**Fit out and operation of the IMAX cinema, The Ribbon (SSD-8839)
Response to Submissions**

Having considered the proposal, the Department requires further clarification and additional information. We require this to demonstrate the proposed fit out is fully consistent with the layouts and building approved under SSD 7388. You are requested to provide a response to the following:

GA PLANS - PODIUM L03

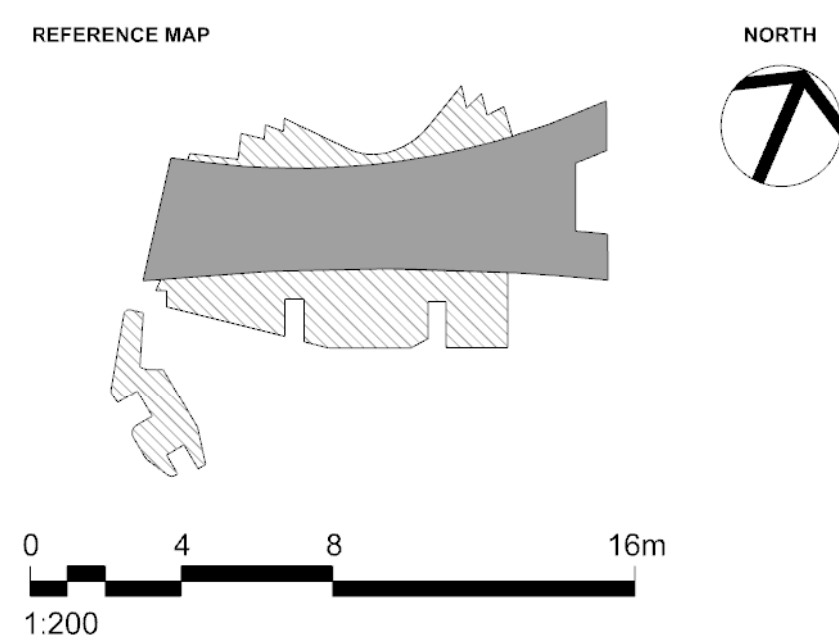
- Submit plans for levels 3 and 4 of the development to confirm consistency with the Ribbon Development Consent SSD 7388. It is noted the recently approved SSD 7388 MOD 8 included plans for the IMAX ground floor and podium levels 1-6 showing the projection room on level 4.
- Review the submitted plans to ensure consistency and accuracy between the Architectural Plans and the indicative fitout plans, specifically the arrangement of seating within the cinema.
- Provide an updated jobs estimate specifying the number of construction and operational jobs relevant to the proposed fit out and operation.
